Engineers Comments Regarding Surface Water Drainage

Application Reference:	BN/64/26/PL	Reviewer Reference:	ADC/EXT5/AF
Planning Officer:	Amber Willard	Date of Review:	18/06/2026
Site Name:	Hill View Eastergate Lane Eastergate PO20 3SJ		
Application Description:	Demolition of existing dilapidated commercial sheds and the erection of 9 No dwellings and associated car parking and landscaping (resubmission following BN/83/25/PL). This application is a Departure from the Development Plan and is in CIL Zone 3 and is CIL Liable as new dwellings.		
Assessment Number:	1

PL400

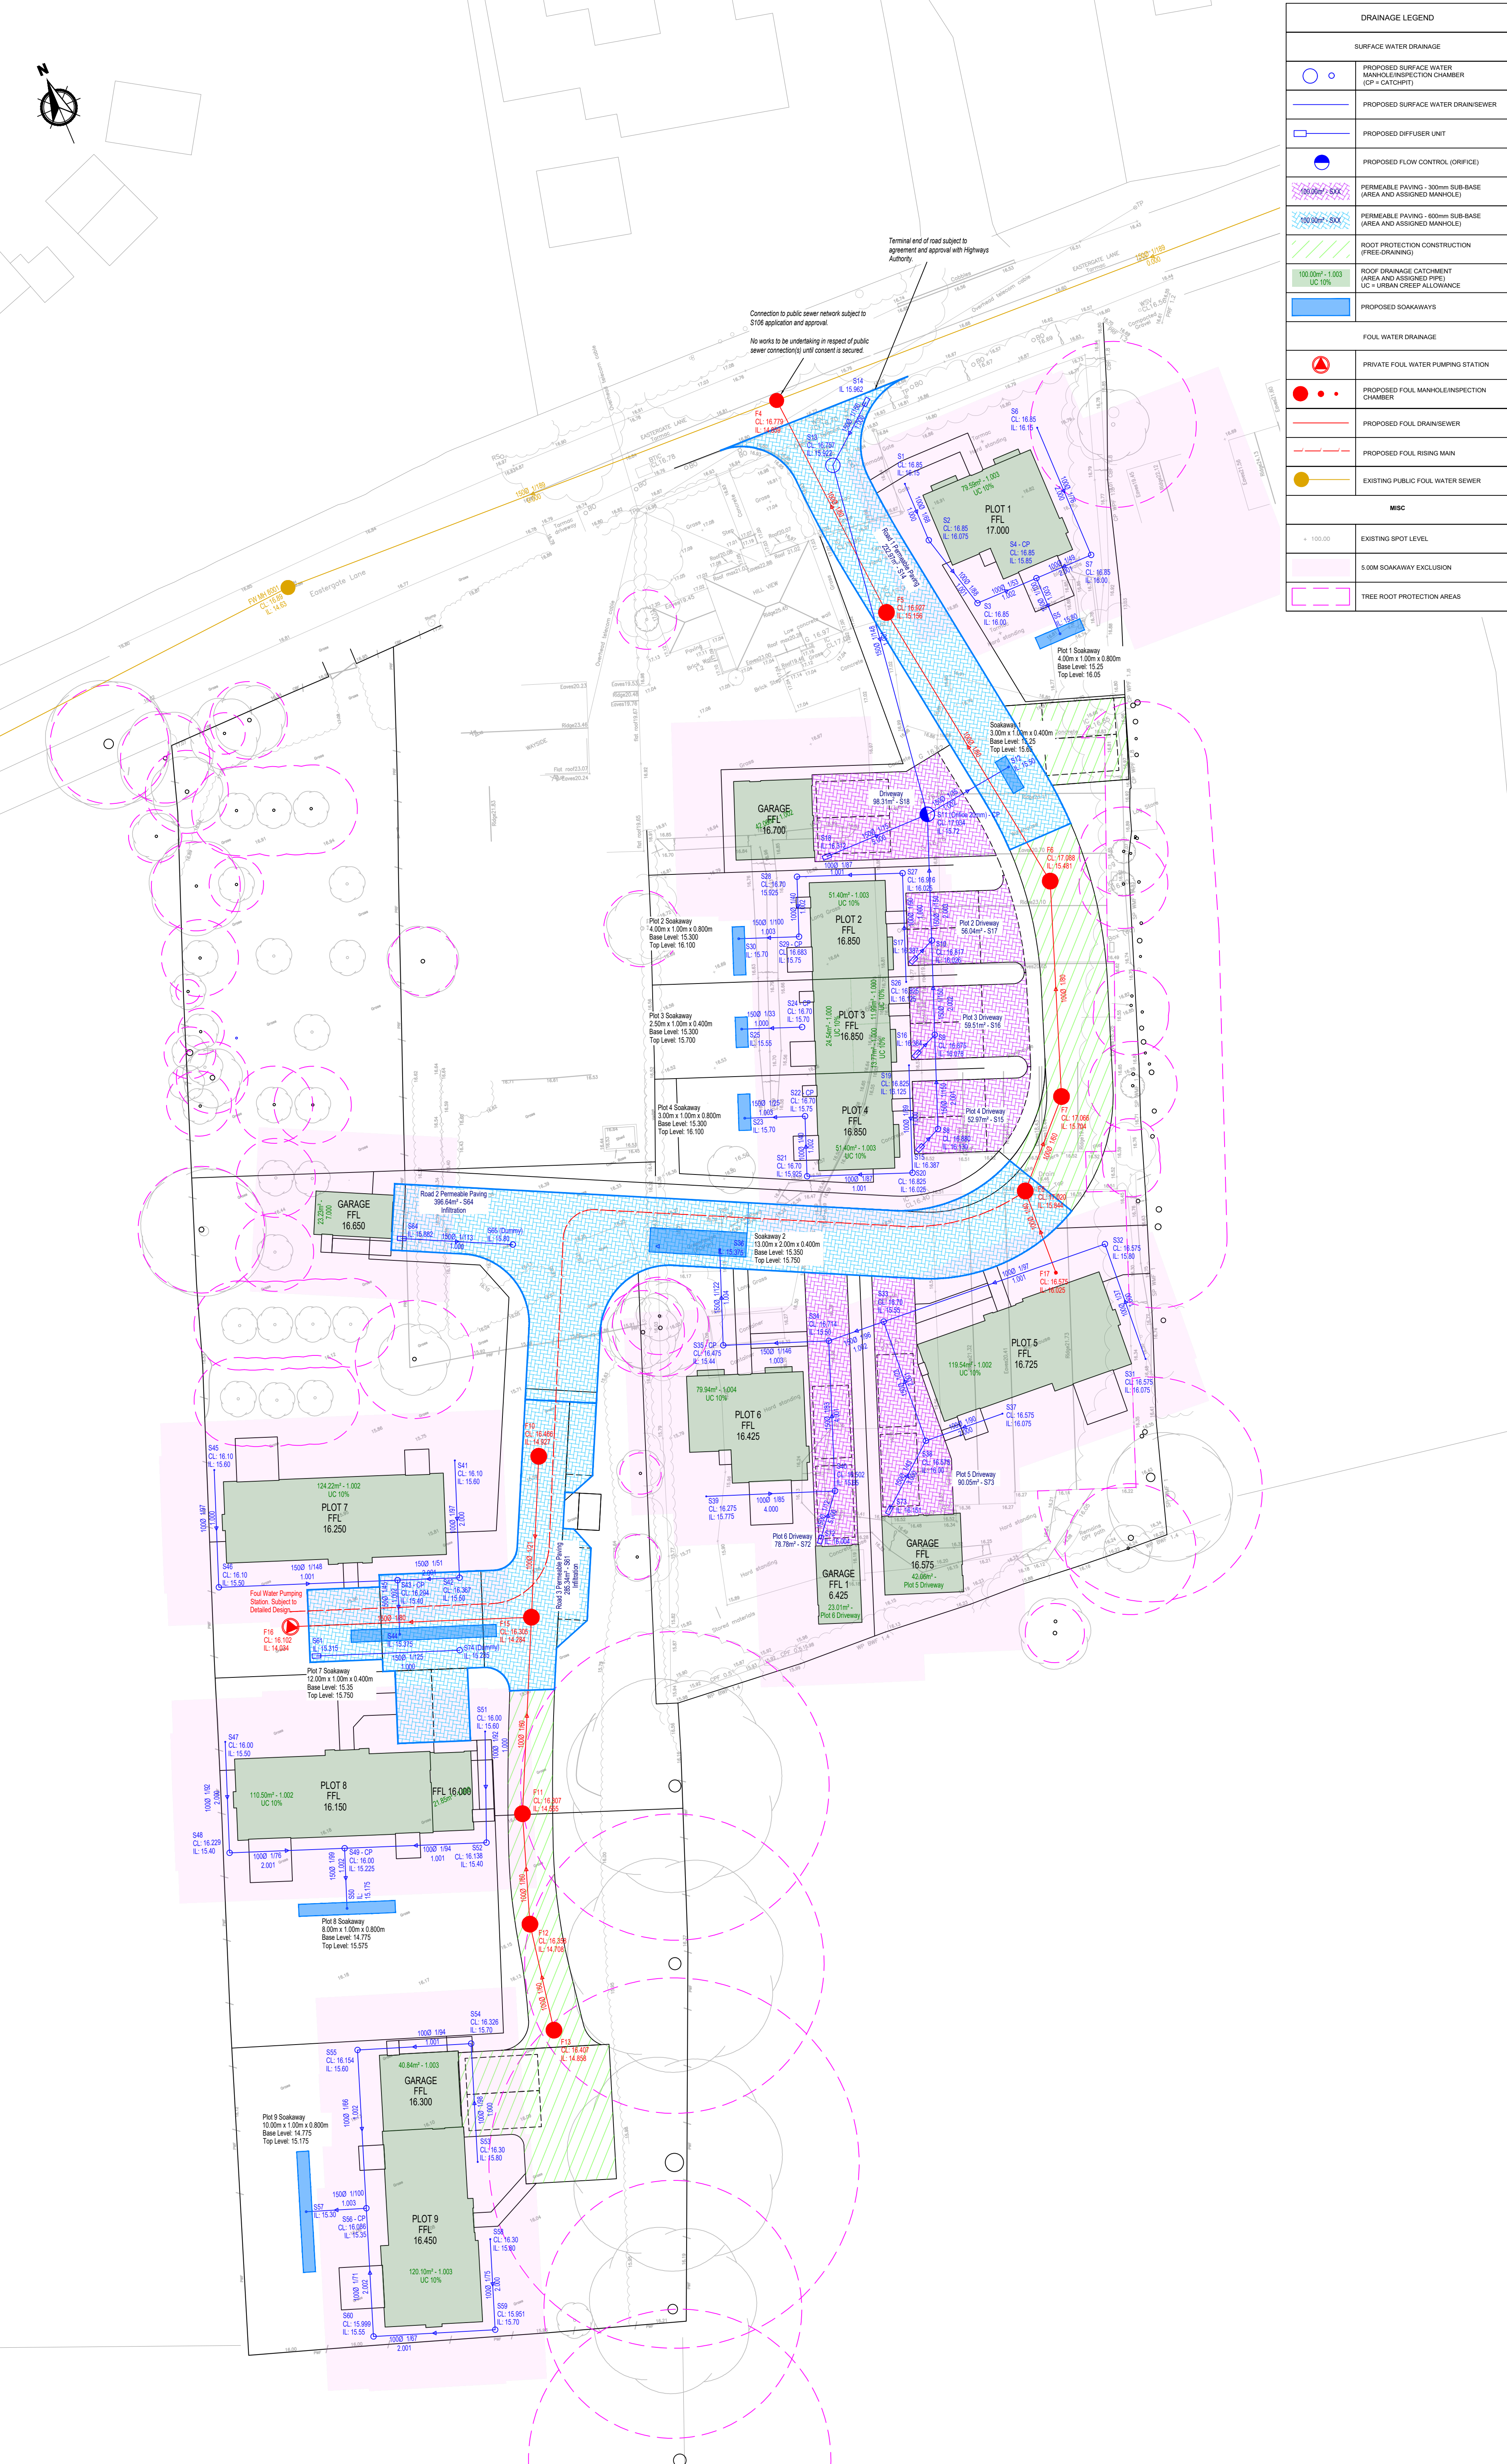
- 3.3. Drain-down times for the 3.3% AEP storm should be provided to confirm that the half-drain time is within 24 hours for each feature.
- 3.4. The Plot 2 soakaway appears to only drain 30 sqm in the calculations whereas the layout plan appears to show 63 sqm.

- 3.5. The calculations do not clarify whether the permeable paving is modelled with a flat base of sloping base. Sloping infiltration blankets could overtop from the low end prior to filling. Base levels of constant depth to base should also be indicated on the drainage layout.

- 3.6. Root protection paving typically does not include a depth of stone storage in the same form as permeable paving. The infiltration / attenuation of the root protection pavement should be clarified.
